Our Ref: EN010115

Date: 22 April 2024

Application by Five Estuaries Offshore Wind Farm Ltd for an Order Granting Development Consent for the Five Estuaries Offshore Windfarm

Advice following issue of decision to accept the application for examination

[Continues on Sheet No. 4]  
 [Continues on Sheet No. 5]

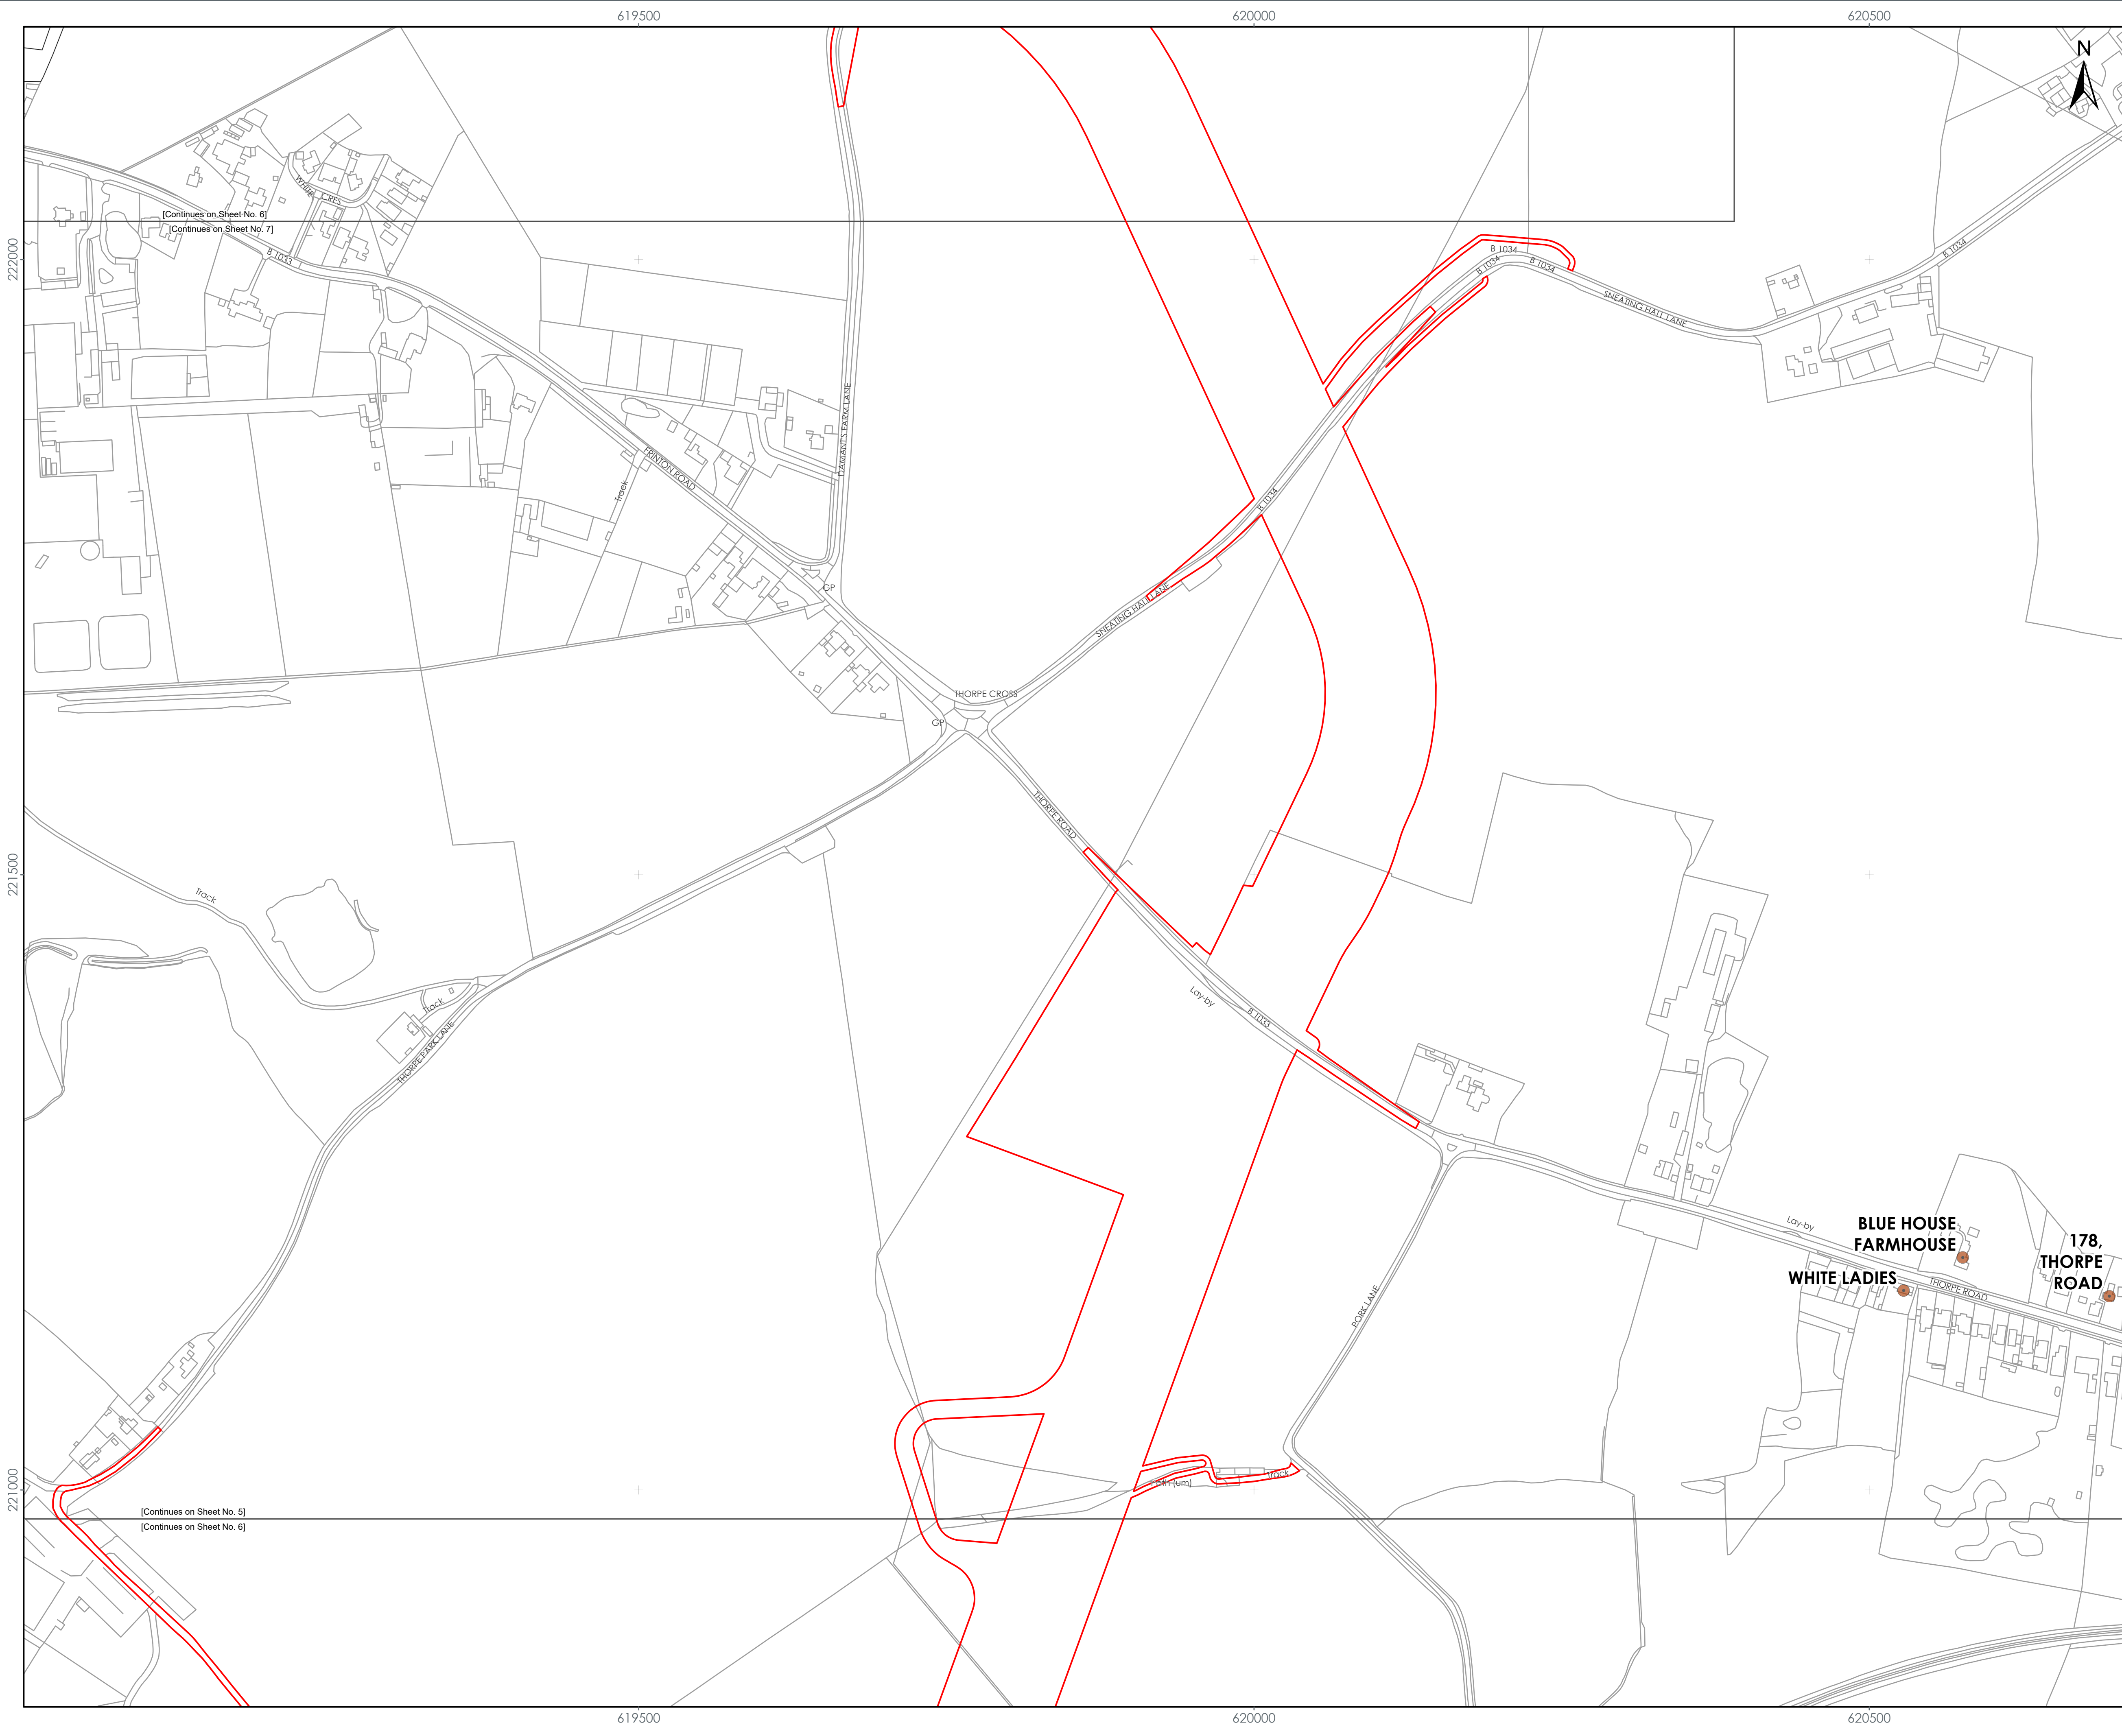
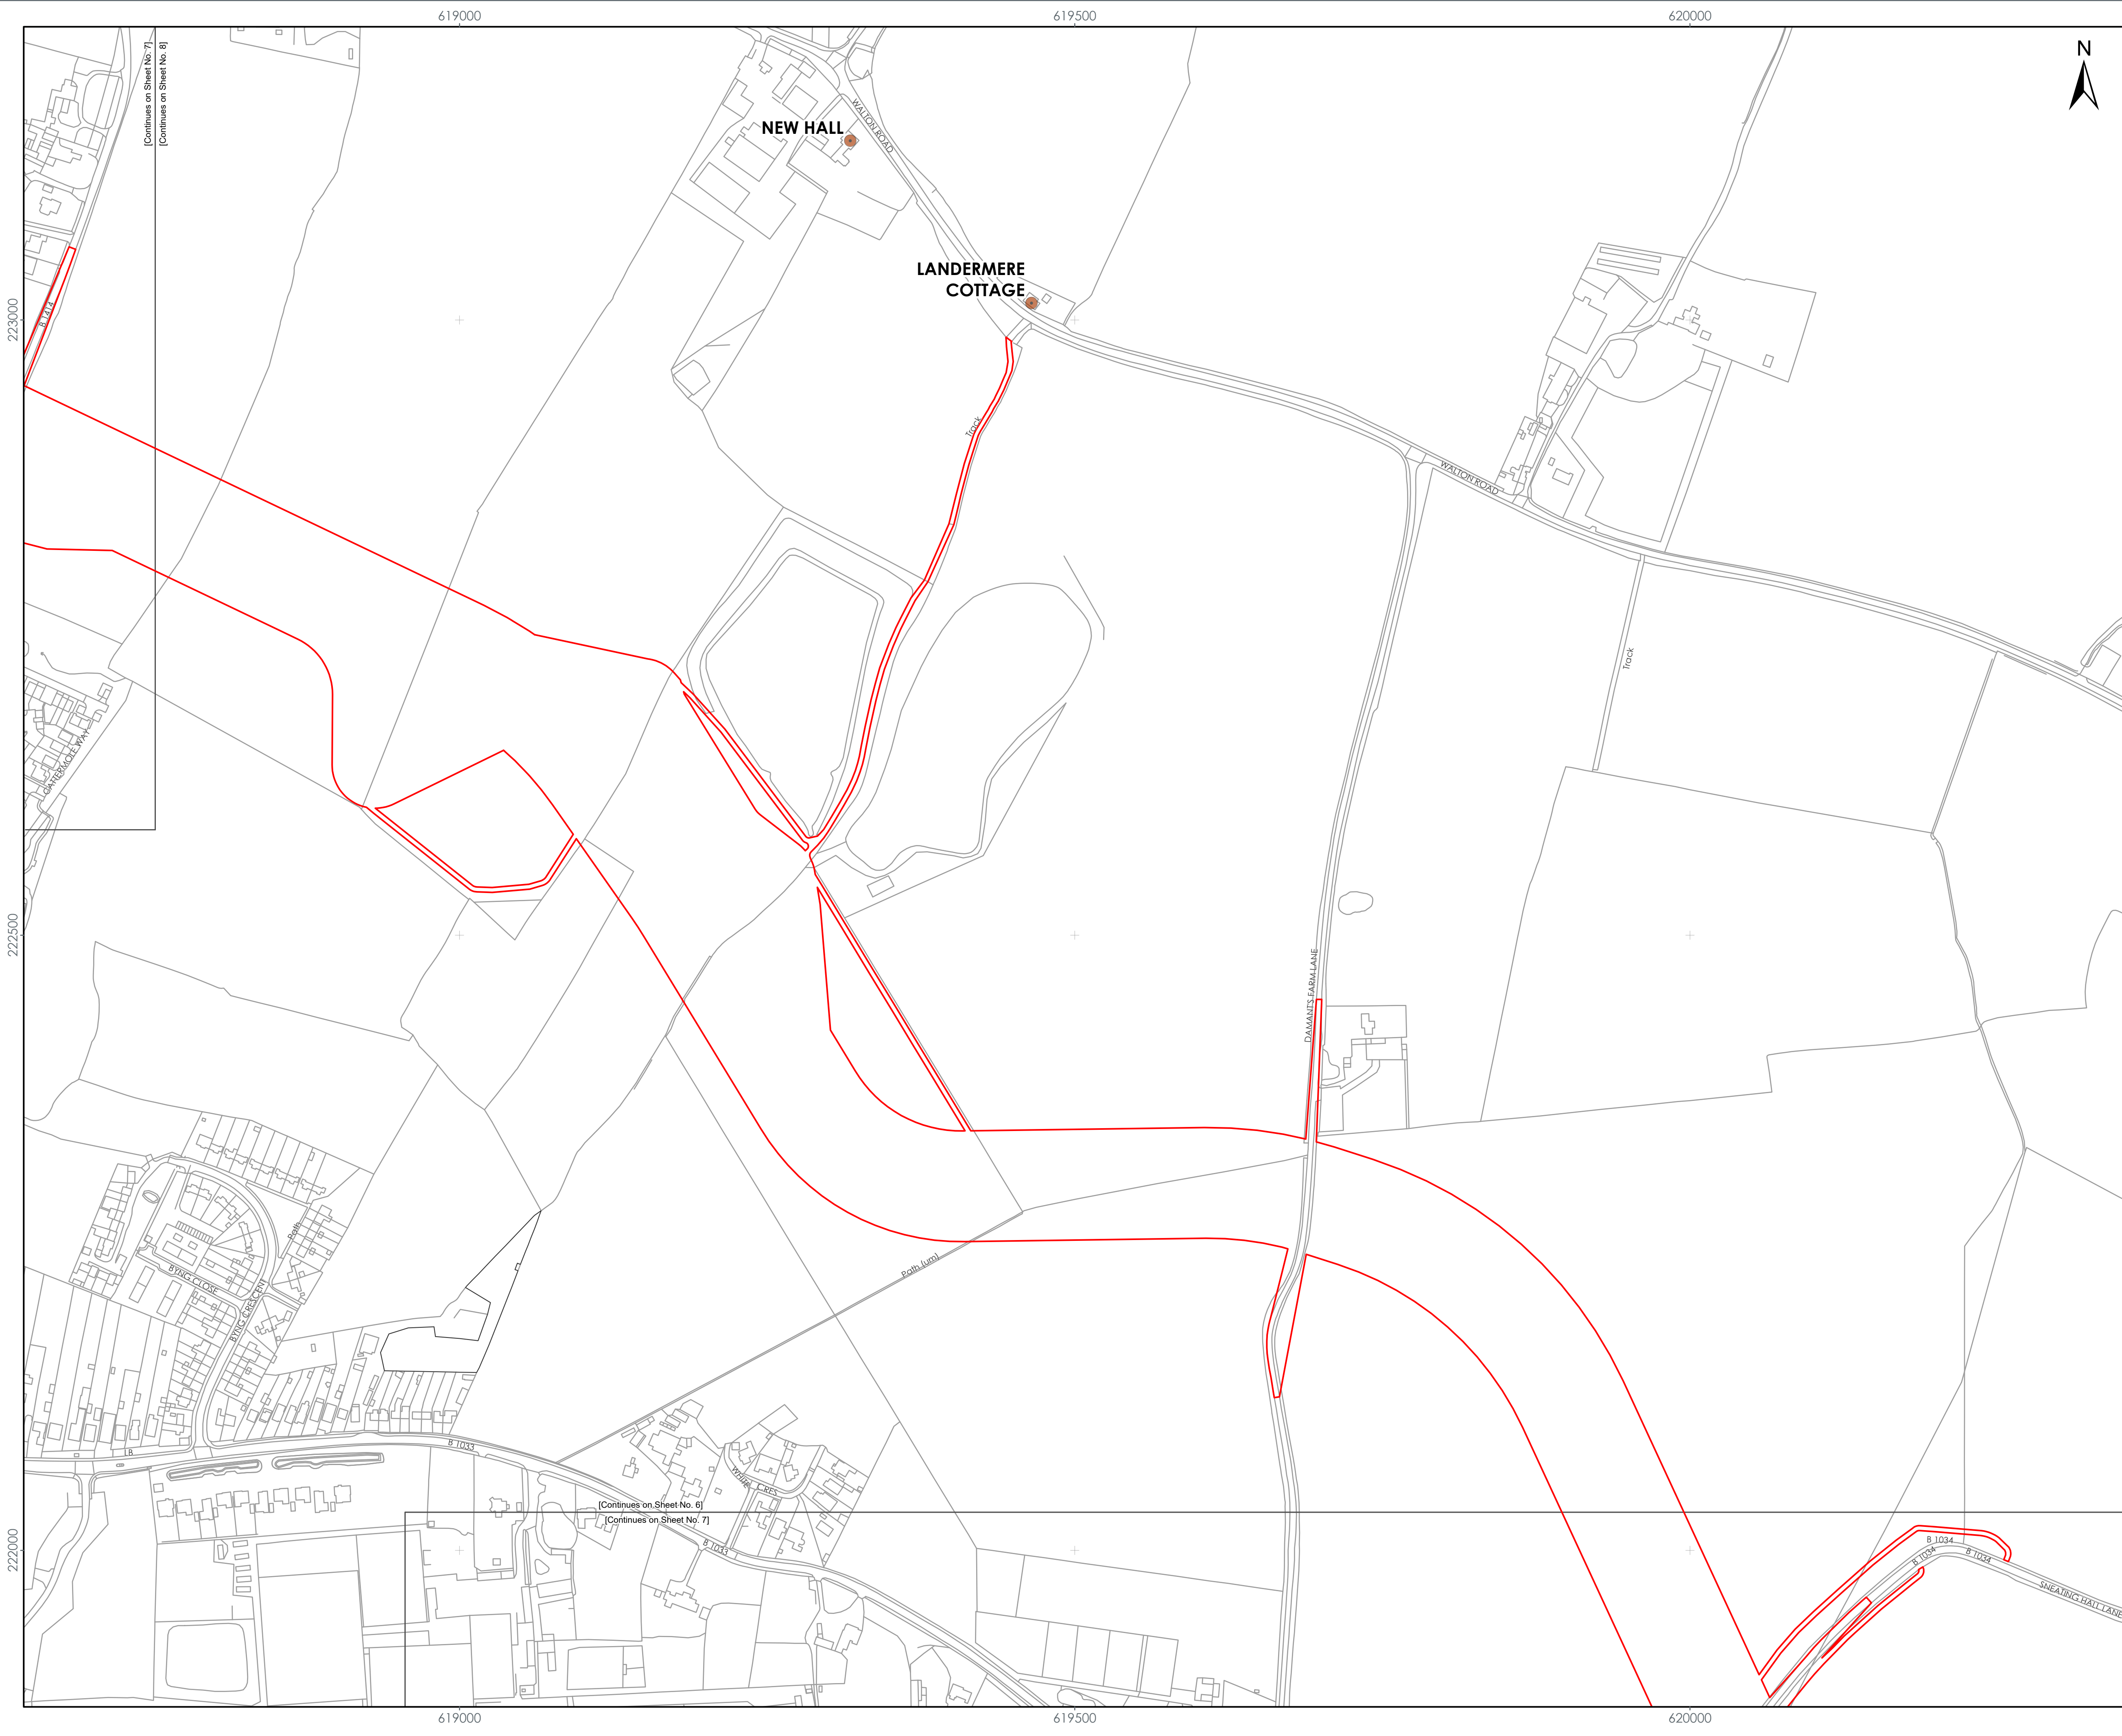
Historic environment plans show a woodland layer on the key, but this is not visible on the plans.

These plans also show ancient woodland which may not be required in the historic environment context and could be included in the **Statutory or Non-Statutory Sites and Features of Nature Conservation - Onshore plans (Doc 2.13)**.
